From: Samantha Lee [REDACTED]
Sent: 02 September 2019 09:26
To: Richard Castro-Parker
Cc: Daniel Vick; Laura Gibbons
Subject: Re: BE/139/18/PL - Innovation Centre Beeding Close

From: Samantha Lee [REDACTED]
Sent: 21 August 2019 11:46
To: Richard Castro-Parker <Richard.Castro-Parker@arun.gov.uk>
Cc: Daniel Vick <Daniel.Vick@arun.gov.uk>
Subject: RE: BE/139/18/PL - Innovation Centre Beeding Close

Further to our telephone calls today, I had already asked the Laura Gibbons about the drainage matters you raised (see my email below). Laura has commented and has requested the following:

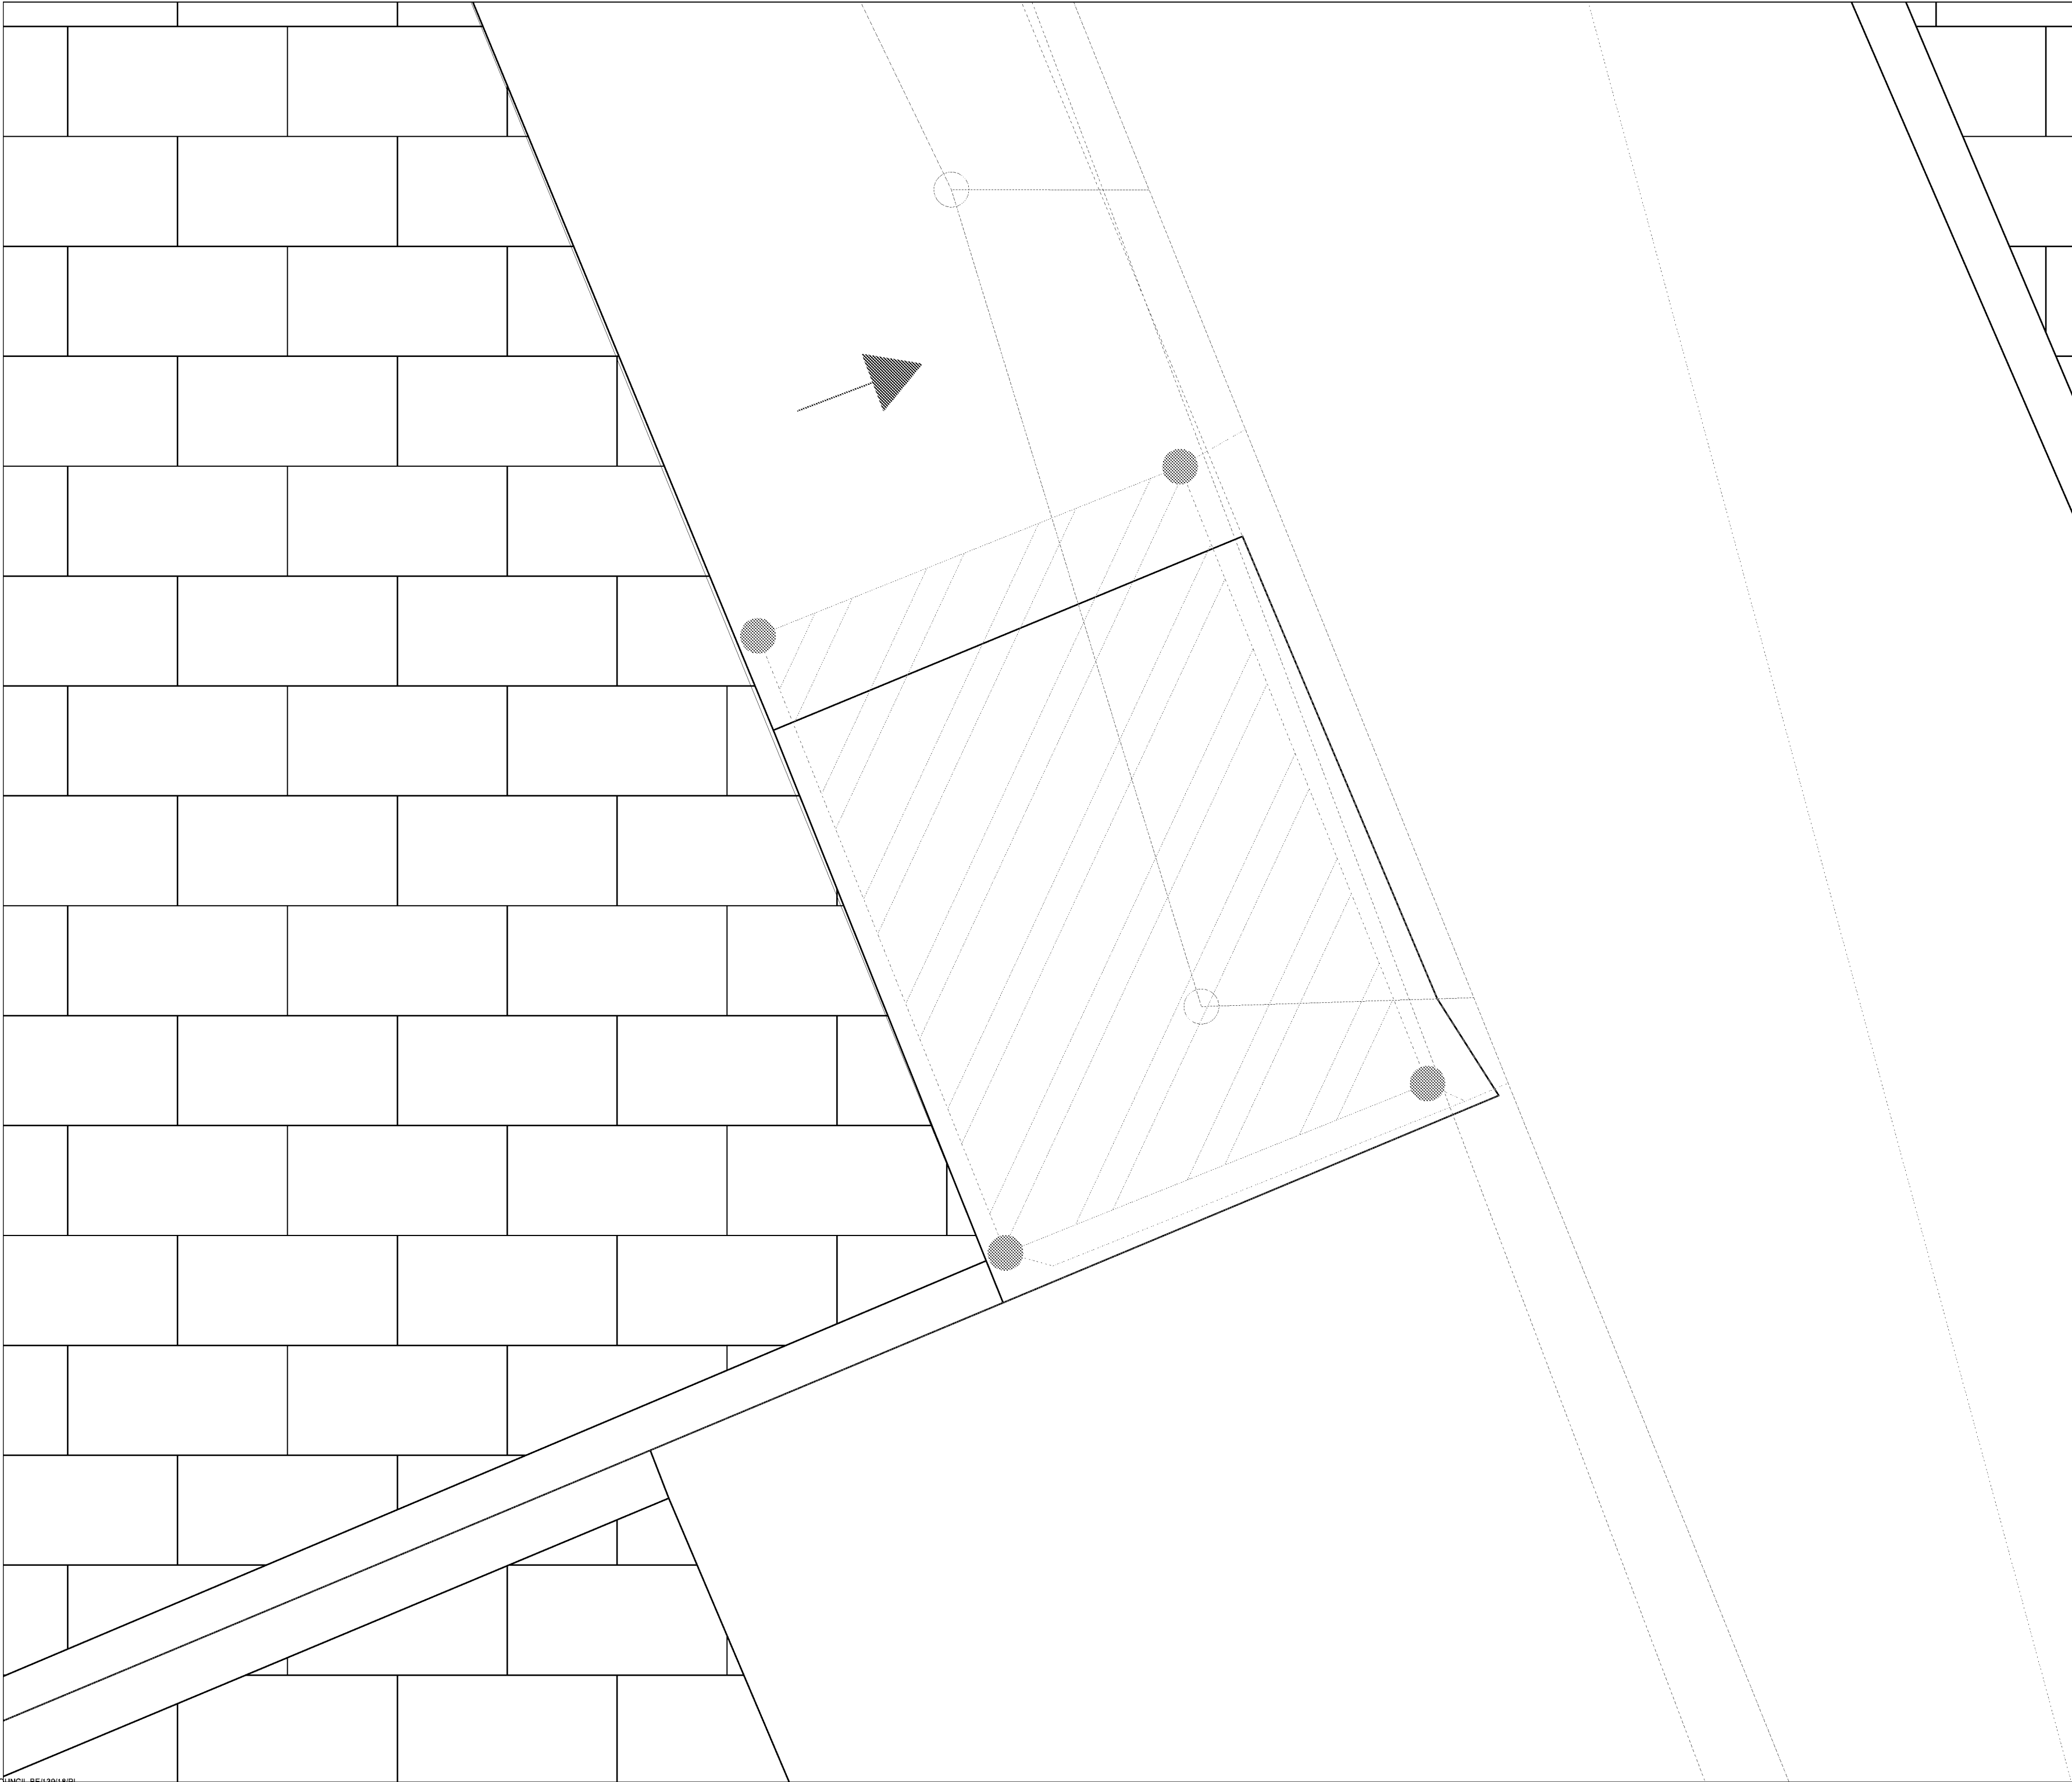
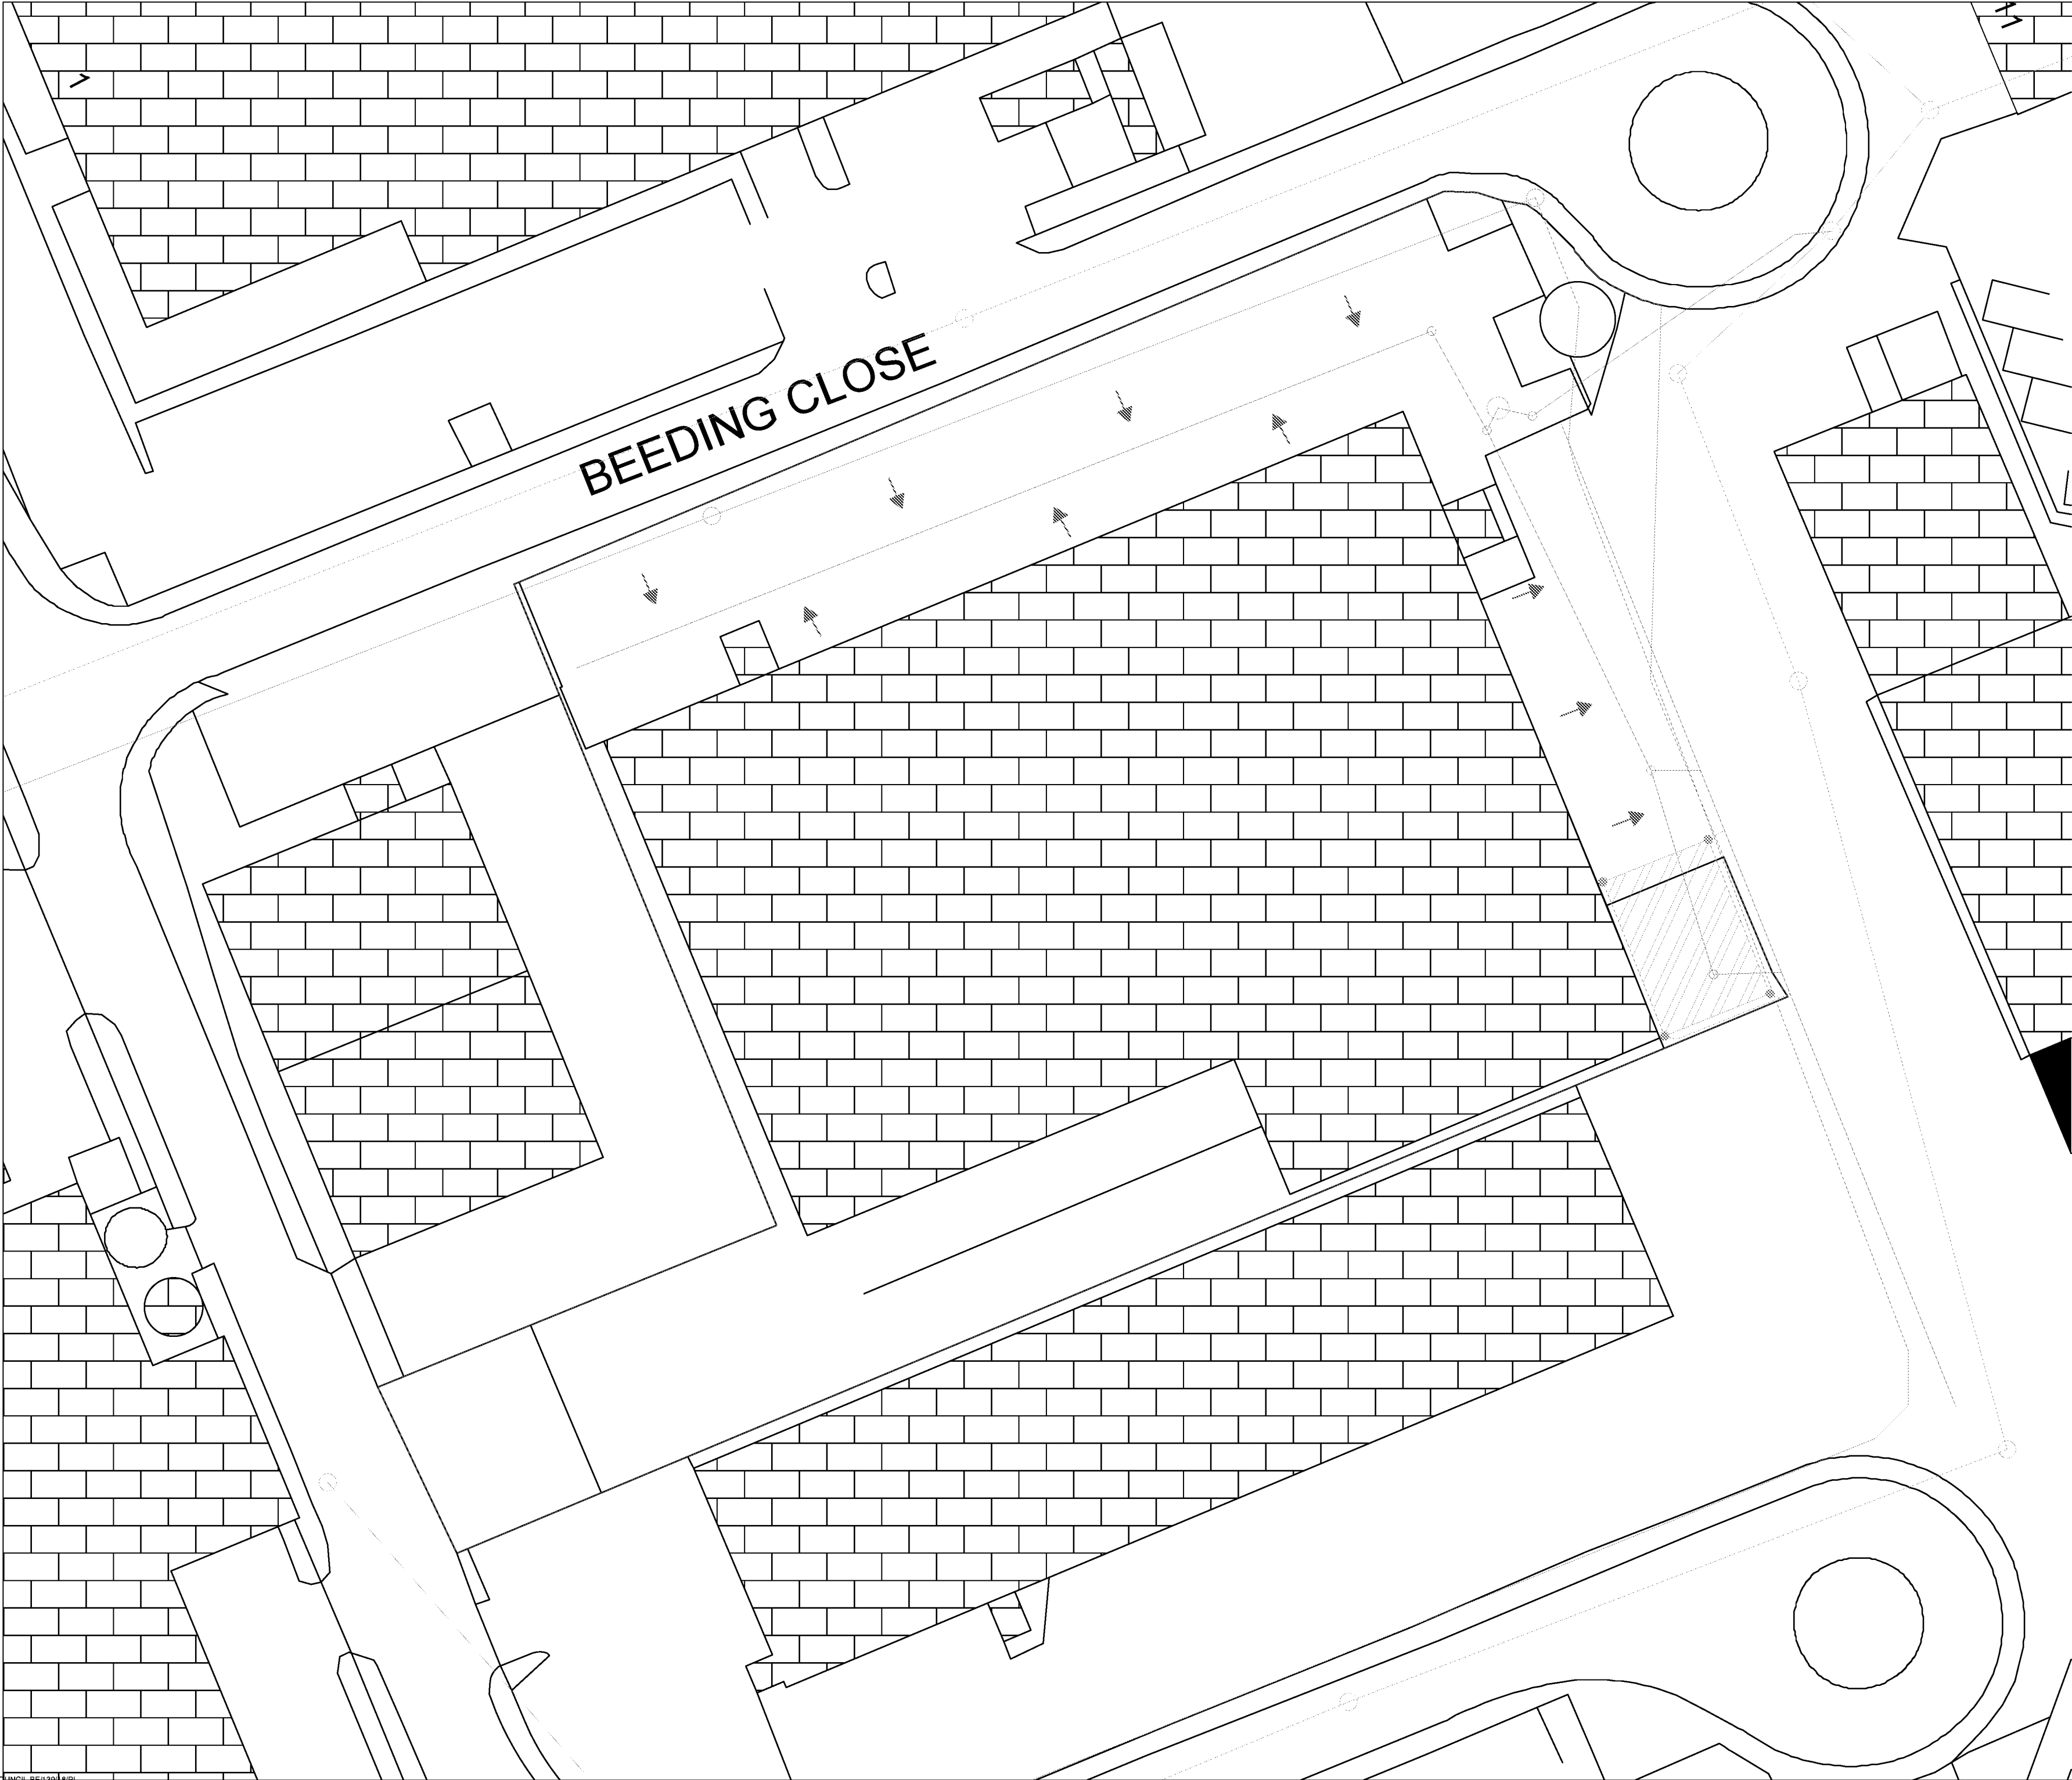
Please can the applicant submit clearer plans of the proposed surface water drainage arrangement. I.e. different line types used, rather than all very similar colours. Please can gullies, manholes, and linear drainage channels be clearly labelled.

I also require levels to be submitted showing invert and cover levels of the existing drainage network and spot levels of the surrounding land. This is fundamental to ensure that the surface water from the development does not go off site.

Please find attached a PDF of the drainage layout plan for the site. Given the size of the site, all lines on the plans are small. However, if Laura zooms in she will be able to distinguish between the pipes types. This should hopefully address her first concern.

With regards to levels, having reviewed the sewer asset location search requested from Southern Water, both invert and cover levels for all Southern Water manholes are detailed within their response. A copy of the sewer asset location search was included within the appendix of the Surface Water Drainage Strategy – this have been attached to this email for her reference.
